WELWYN HATFIELD BOROUGH COUNCIL – DEVELOPMENT MANAGEMENT
DELEGATED REPORT

APPLICATION No:	S6/2013/0023/FP
APPLICATION Site:	Oak Cottage, 4 Wilkins Green Lane, Hatfield

TITLE Proposed First Floor Plan		
PROJECT NAME Oak Cottage, 4 Wilkins Green Lane, Hatfield, AL10 9RT		
DRAWN BY E.B	DATE August 2012	
SCALE 1:100 @ A1	CHECKED	
DRAWING NO. EL/2012/06	REV. NO. -

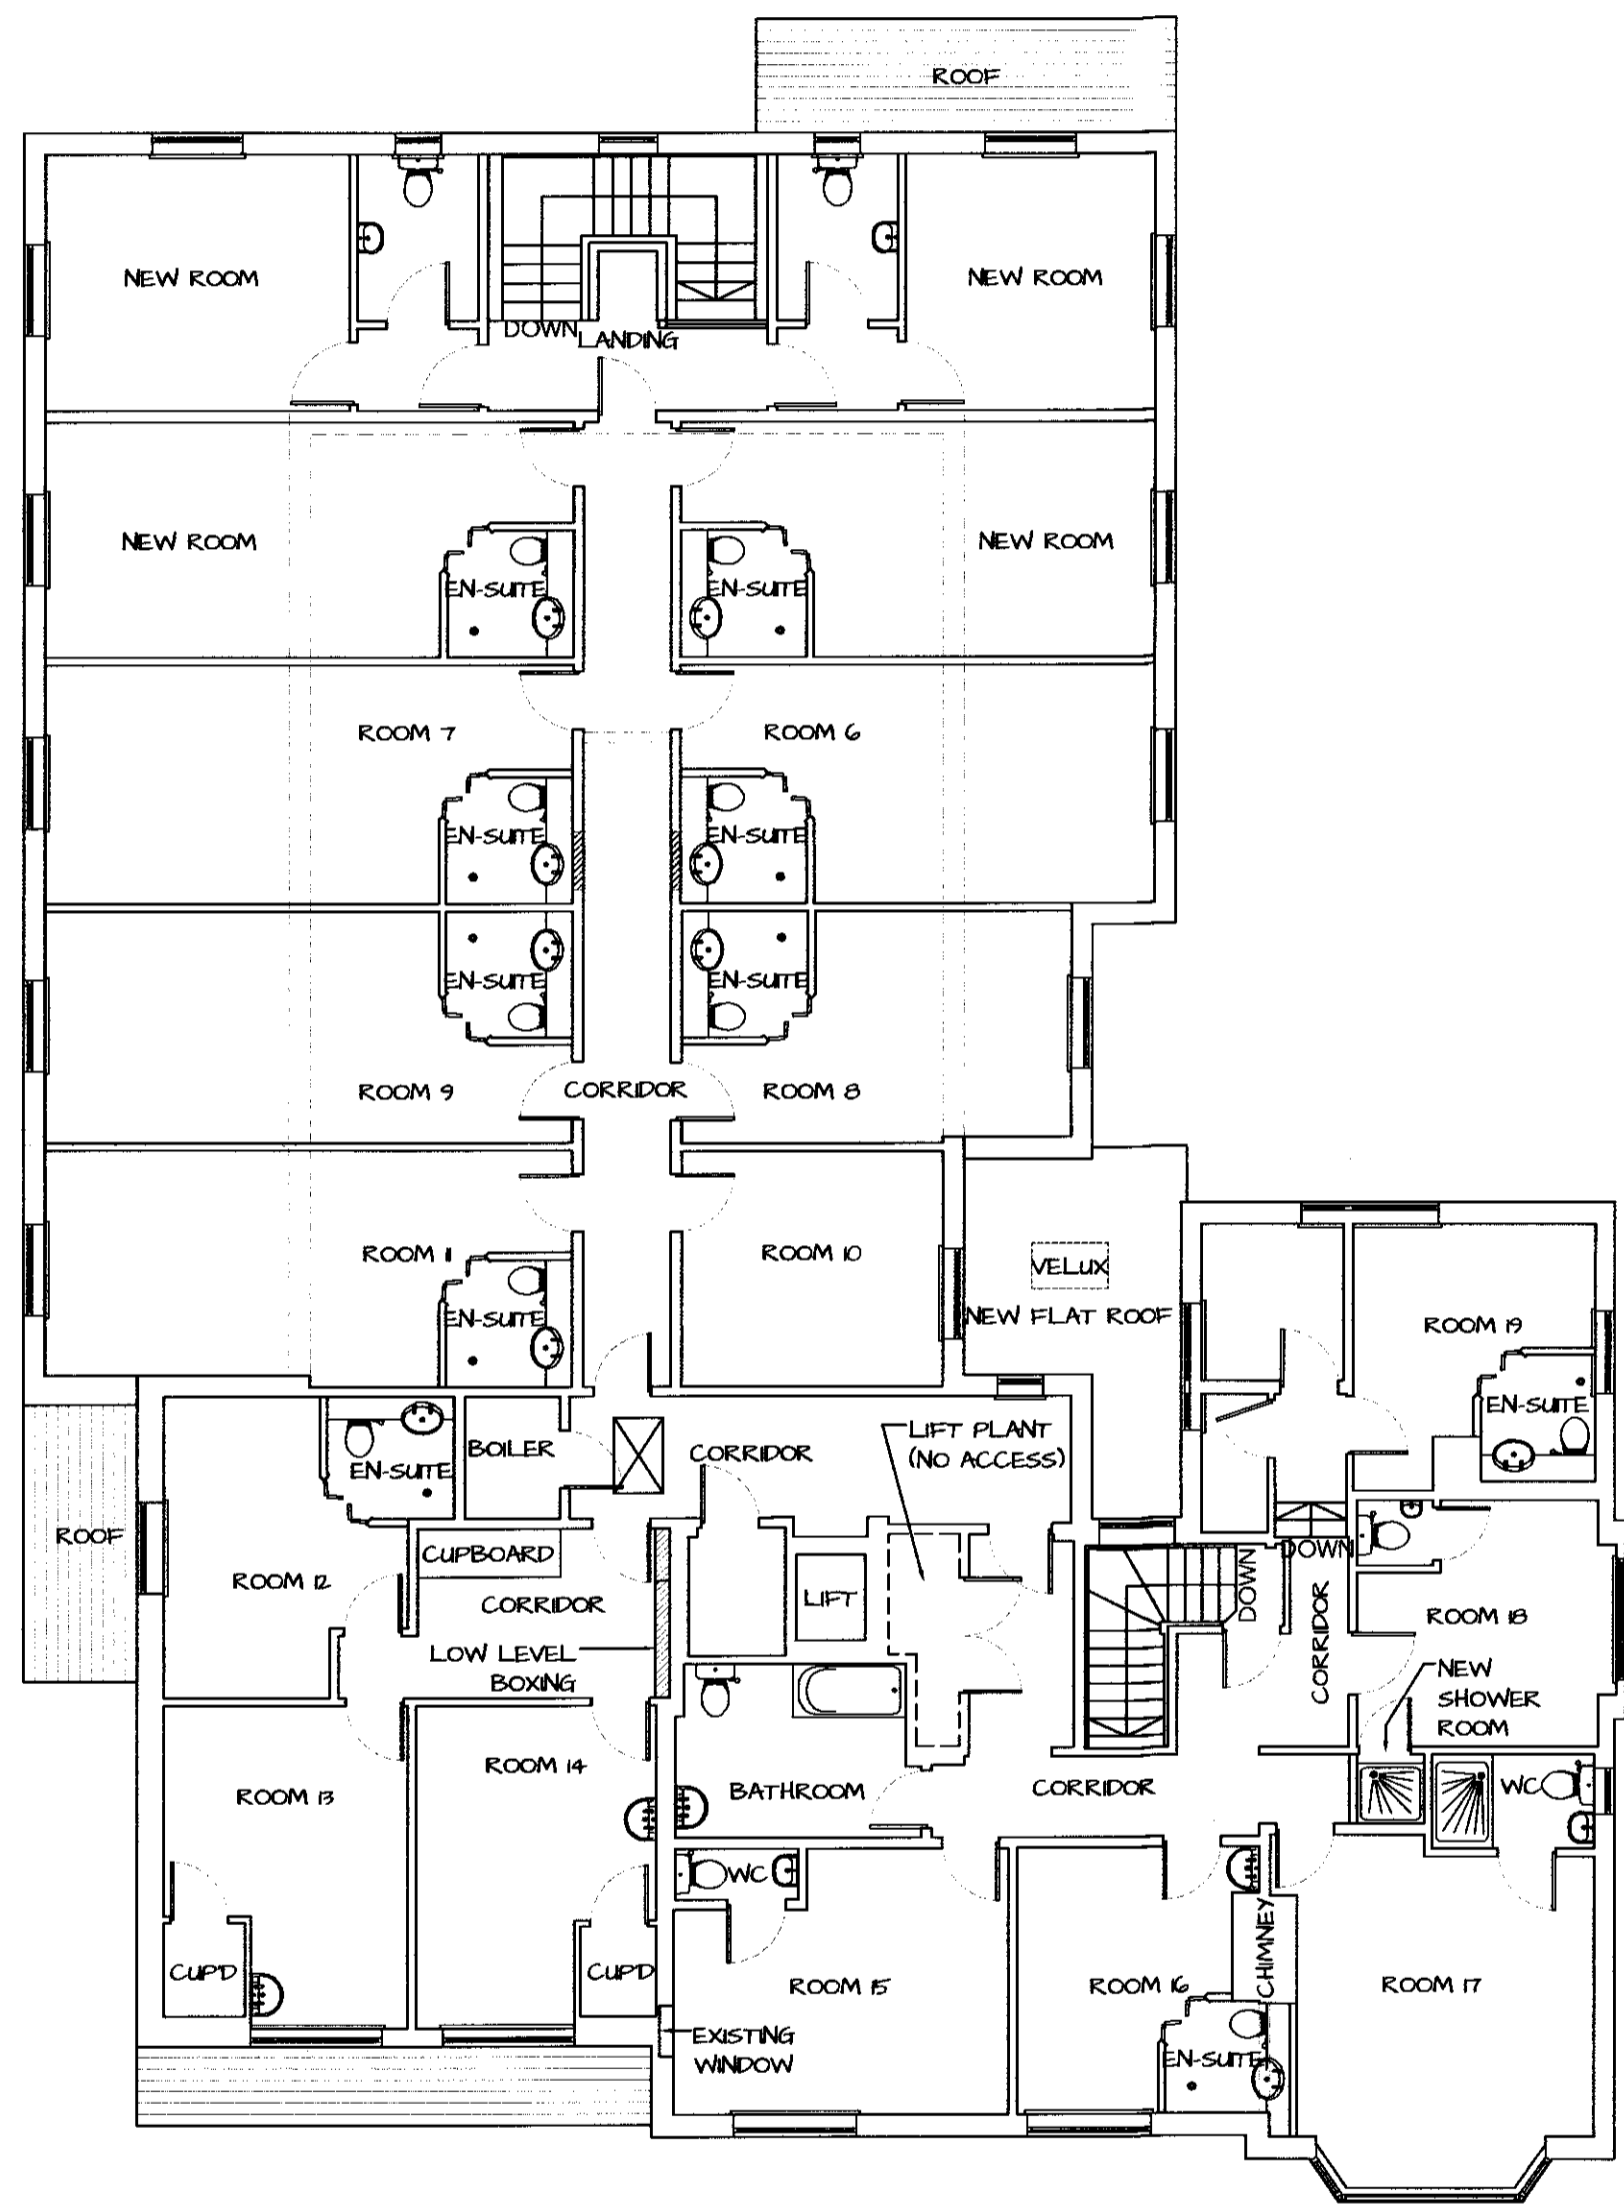
The proposal would result in several side facing first floor windows being sited closer to the side boundaries of the plot. It has been acknowledged that the existing building does have some side facing first floor windows; however, these have a greater separation from the side boundaries of the plot and very limited views of the private areas of neighbouring plots. The proposed western side of the extension would have a distance of approximately 2.2m from the side boundary of the plot. As the proposed windows would serve larger rooms for the residents of a care home, which the occupants are likely to spend more time in, it is necessary that an appropriate outlook is retained to these rooms and obscure glazing would not allow appropriate residential amenity standards for the care rooms. It has been noted that there was a condition to obscure glaze first floor side windows on a previous approval, however, this previous scheme involved an extension to the rear of the buildings and most of the rooms were dual aspect. Therefore only one room would have had obscure glazing to its only window and the rooms were not labelled as forming bedroom or habitable accommodation so it could have been used for a different function.

Number 5 has clear glazed windows within the side elevation facing the application dwelling which are secondary windows to a bedroom at first floor level and a lounge at ground floor level. Furthermore, this property has a clear glazed conservatory to the rear of the property. It has been noted that the current boundary treatment separating the application site and number 5 is tall and dense; however, planting and hedges cannot be solely relied upon as a permanent screen. The existing boundary treatment is not worthy of protection and could be removed any time or suffer from

disease or storm damage. Therefore, the proposed development would result in an unacceptable further overlooking and loss of privacy to the occupiers of number 5.

2. The proposed development by reason of the proximity to the flank boundaries of the plot and first floor window positions would result in direct and perceived overlooking of the neighbouring properties and adjacent private garden spaces, which would result in a loss of privacy and residential amenity to the adjoining occupiers. The proposal therefore fails to comply with Policies D1 and CLT17 of the Welwyn Hatfield District Plan 2005.

DRAWING NO.
EL/2012/05

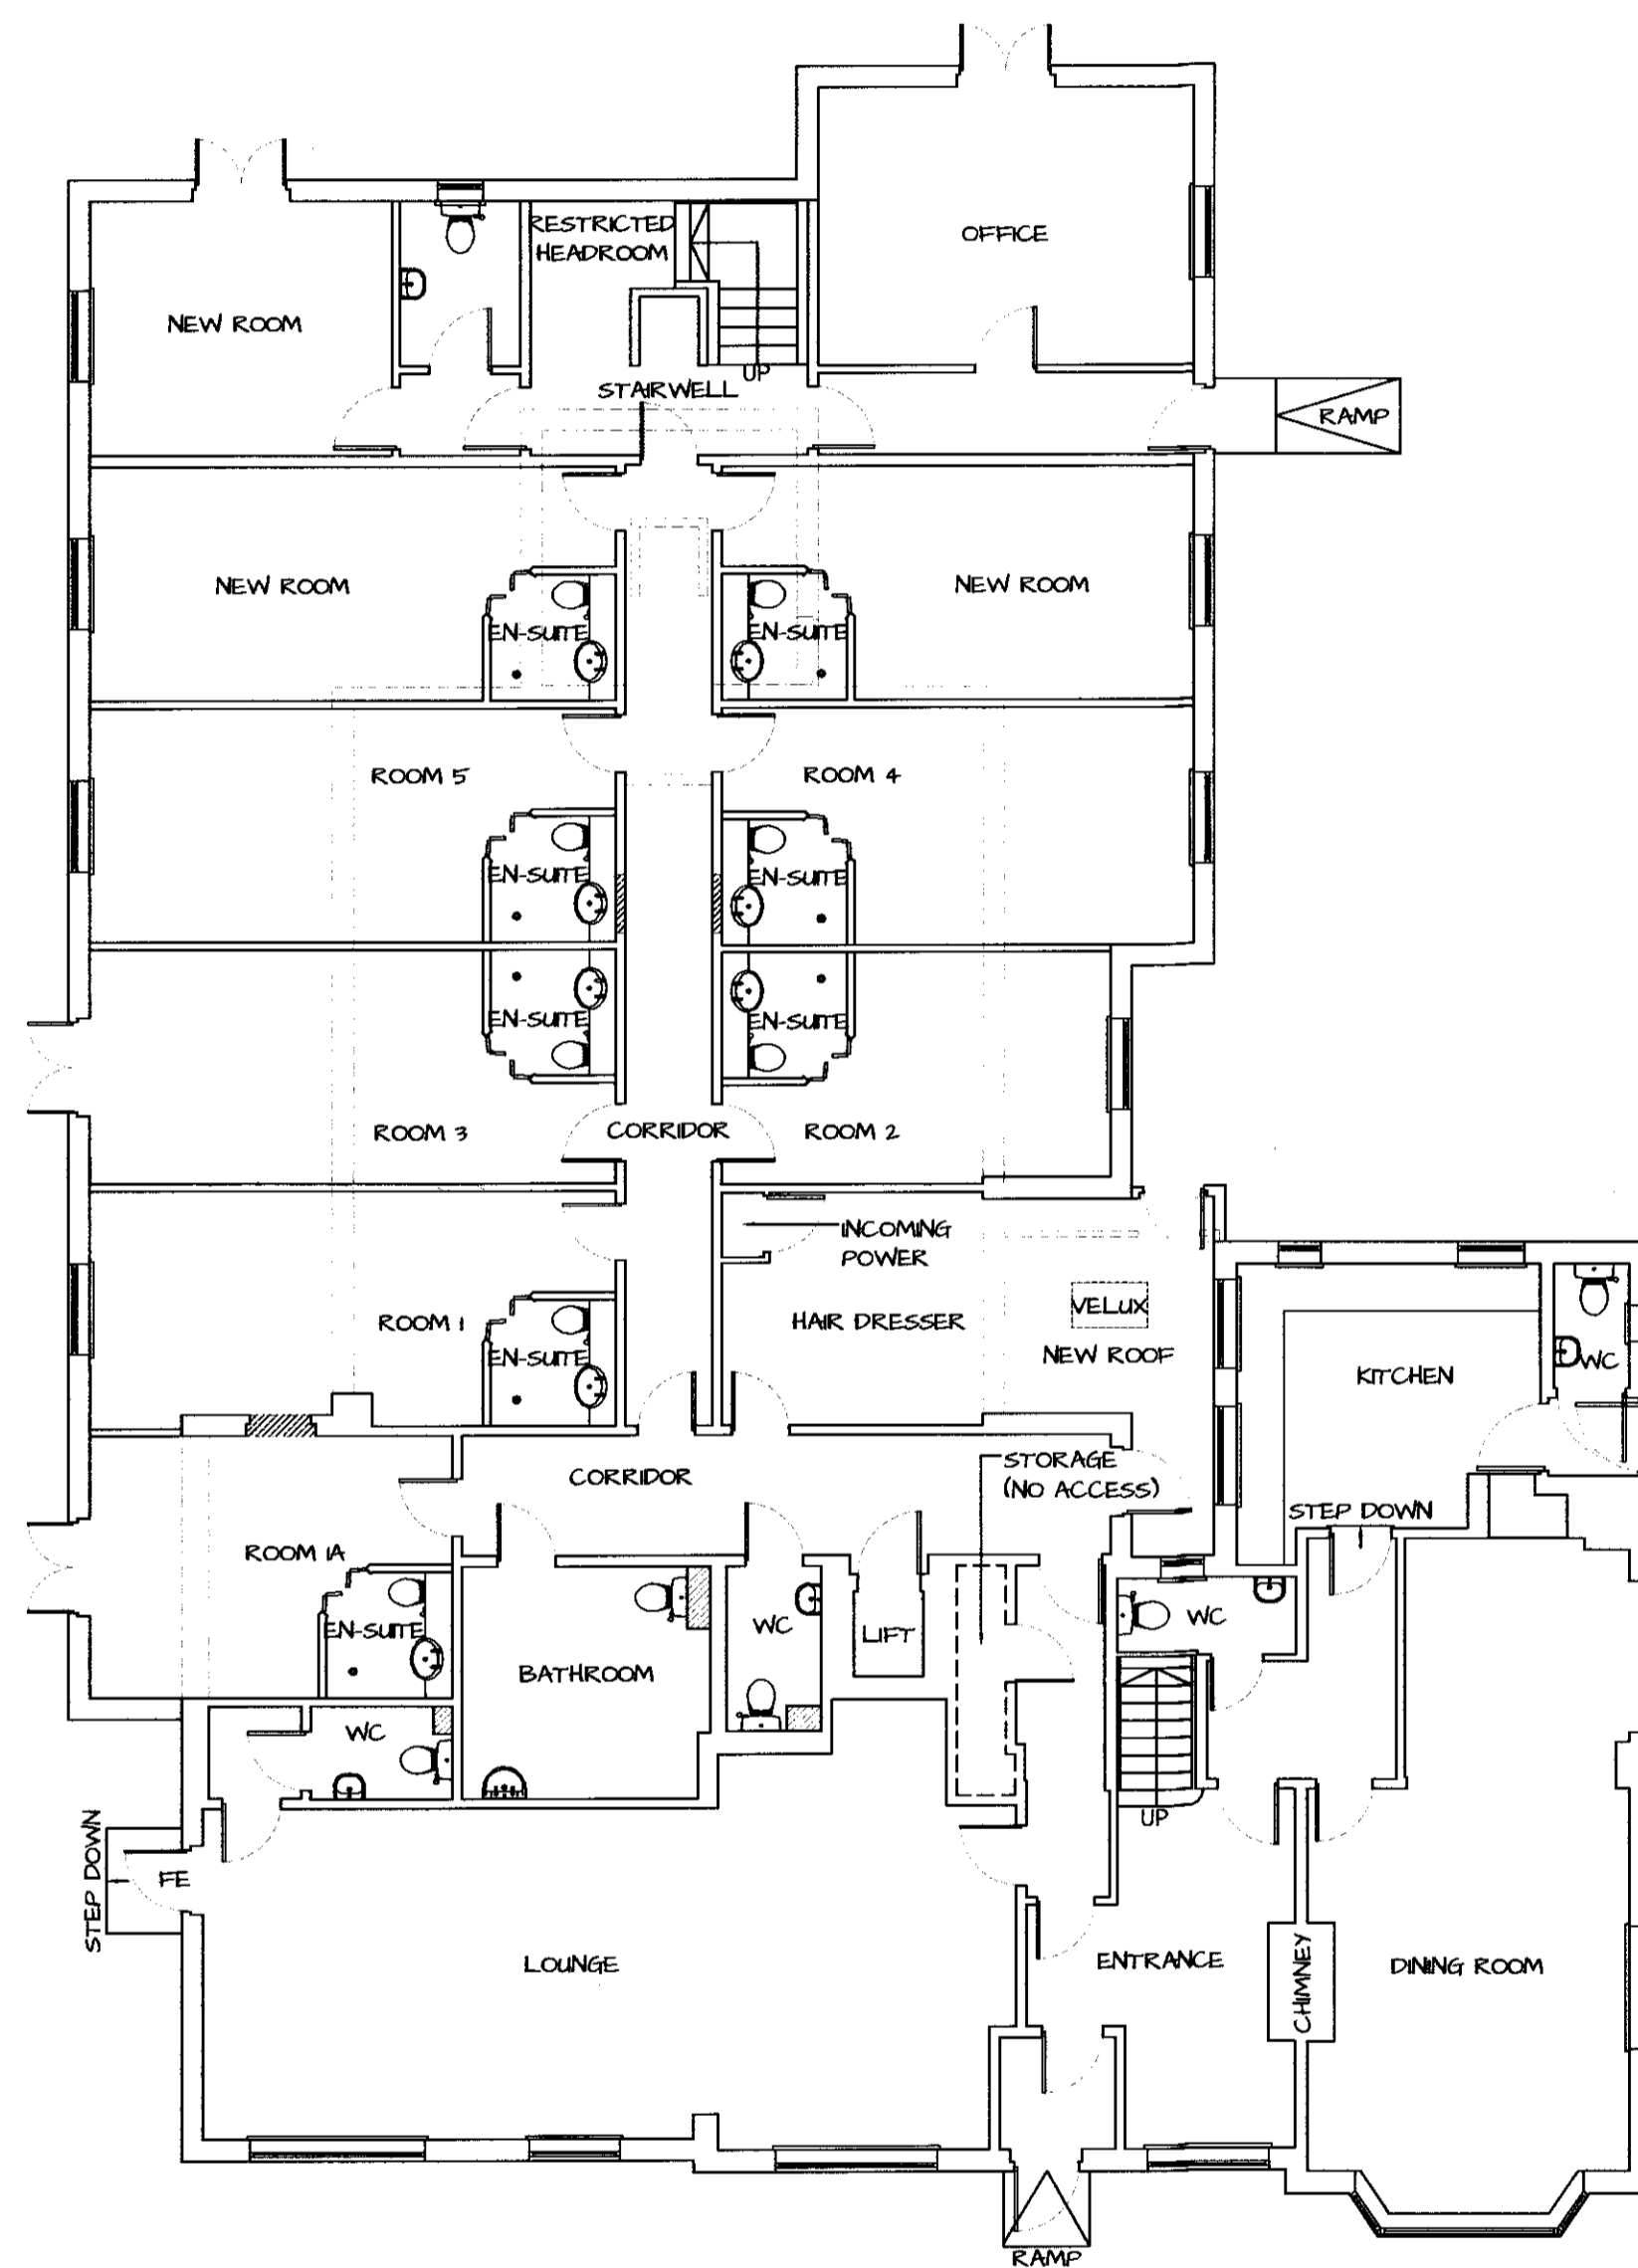
The proposed development would be mostly sited to the rear of the main building and would be set back from the existing main front elevation. The existing building has been previously extended and has an unusual shape. The proposal would add a large two-storey addition that would not be subordinate in scale and would not reflect the design of the existing dwelling. As a result the side elevations of the building would have a significant depth and two-storey gable elements. The proposal's roof would comprise a combination of different features including gables, hipped areas and flat roofs. The extent of the proposal's complicated and contrived roof indicates that the resultant building would be too large to accommodate an in keeping pitched roof without it being excessively tall. Therefore, the proposal would not directly meet the design requirements of Policy D1 of the Welwyn Hatfield District Plan 2005.

The proposal would significantly increase the depth of the building's main flank wall to the west and add to the bulk and massing of the property considerably. The additional development would mostly be viewed from the adjacent plots but there would also be glimpses of the western side elevation from the front of the property. The proposed development would not respect the character and appearance of the original property and would result in a building which is out of proportion with the surrounding residential dwellings.

1. The proposed development by reason of its height, depth, bulk and design would appear overly dominant and obtrusive when viewed from the neighbouring properties and land. The proposal would not be subordinate in scale and would fail to reflect or complement the design and character of the existing building. The resultant building would appear too prominent and out of place which would affect the visual amenities and character of the area. The proposal therefore would fail to meet the design requirements of Policies D1, D2 and CLT17 of the Welwyn Hatfield District Plan 2005.
